Item No. Report of the Interim Director of Planning, Regeneration & Public Realm

Address: 56 DIAMOND ROAD RUISLIP

Development: Retrospective application for the erection of front porch

LBH Ref Nos: 16429/APP/2022/3717

**AS-BUILT
GROUND FLOOR PLAN**

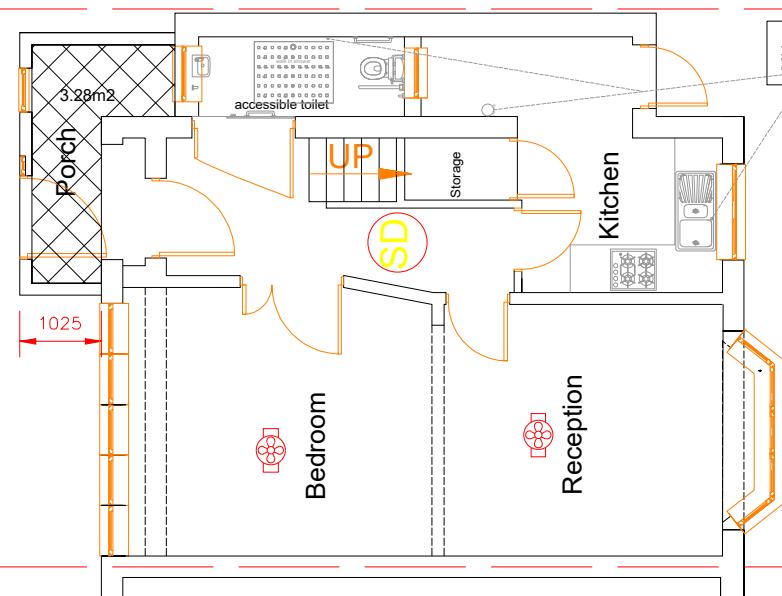
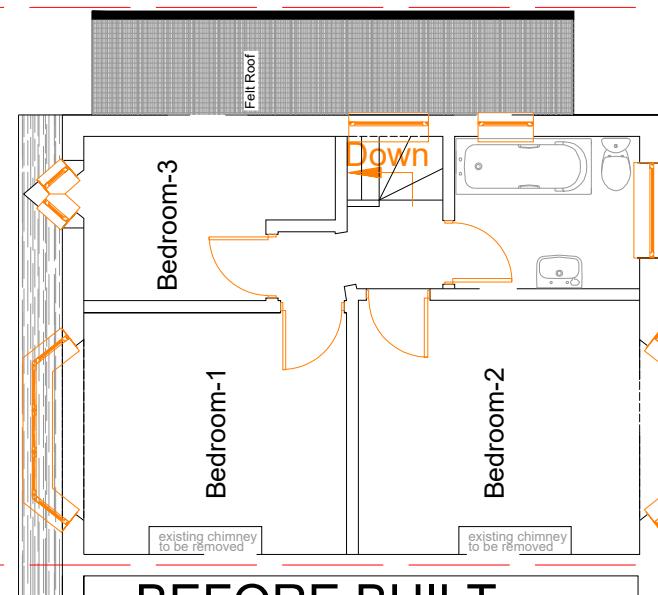
- The submitted Design & Access Statement states that the porch is required to improve/facilitate accessibility for an occupier of the house with quadriplegia (paralysis of all four limbs). This appears not to be the case, as the supporting GP correspondence states "walking difficulty".
- The depth of the porch is shown at 1025 mm which would not achieve sufficient distance between the two sets of doors, making wheelchair access awkward and more difficult than it would be without the porch.
- There is a step up to the porch of some 200 mm (not measured) and what looks to be a high-profile threshold, rendering the whole arrangement unsuitable for a wheelchair user with quadriplegia.
- The entrance level WC (accessible toilet shown on plan) will be suitable for an ambulant disabled person, it would not suit a wheelchair user.

The Accessibility Officer concluded that the plans and evidence presented indicate that a full-time wheelchair user would not receive any notable benefits with the construction of the porch.

**AS BUILT FRONT ELEVATION**

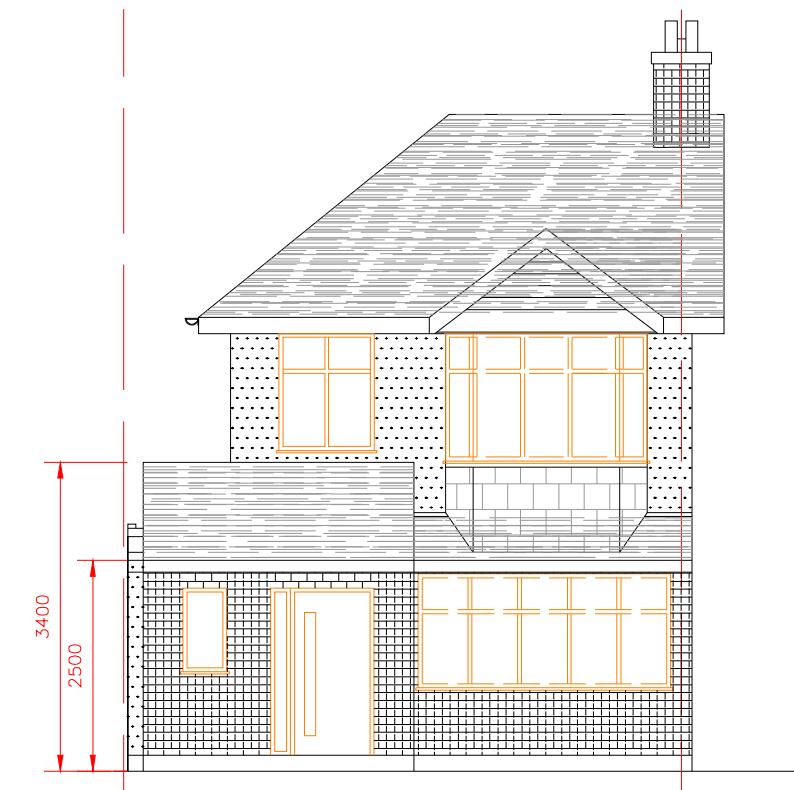
The front porch subject of this application would, by reason of its scale and siting, visually and physically compete with the property's bay window. The porch projects forward of the existing bay window and because of its size, height and forward projection it appears as an incongruous and visually dominant addition to the property. This unacceptable harm would be accentuated by the disruption caused to the cohesive design and building line of the properties on this section of Diamond Road.

Having regard to the above, it is considered that the proposal would cause harm to the character and appearance of the host dwelling and the visual amenities of the surrounding area. In this respect, the proposal therefore conflicts with Policy BE1 of the Hillingdon Local Plan: Part One Strategic Policies (2012) and Policies DMHB 11, DMHB 12 and DMHD 1 of the Hillingdon Local Plan: Part Two - Development Management Policies (2020), policy D3 of the London Plan and Chapter 12 of the National Planning Policy Framework.

The porch, by virtue of its siting, scale, width, height, massing and forward projection, would cause unacceptable harm to the character and appearance of the surrounding area and the host property. The development therefore conflicts with Policy BE1 of the Hillingdon Local Plan: Part One - Strategic Policies (November 2012) and Policies DMHB 11, DMHB 12 and DMHD 1 of the Hillingdon Local Plan: Part Two - Development Management Policies (January 2020), Policy D3 of the London Plan (2021) and Chapter 12 of the National Planning Policy Framework (2021).
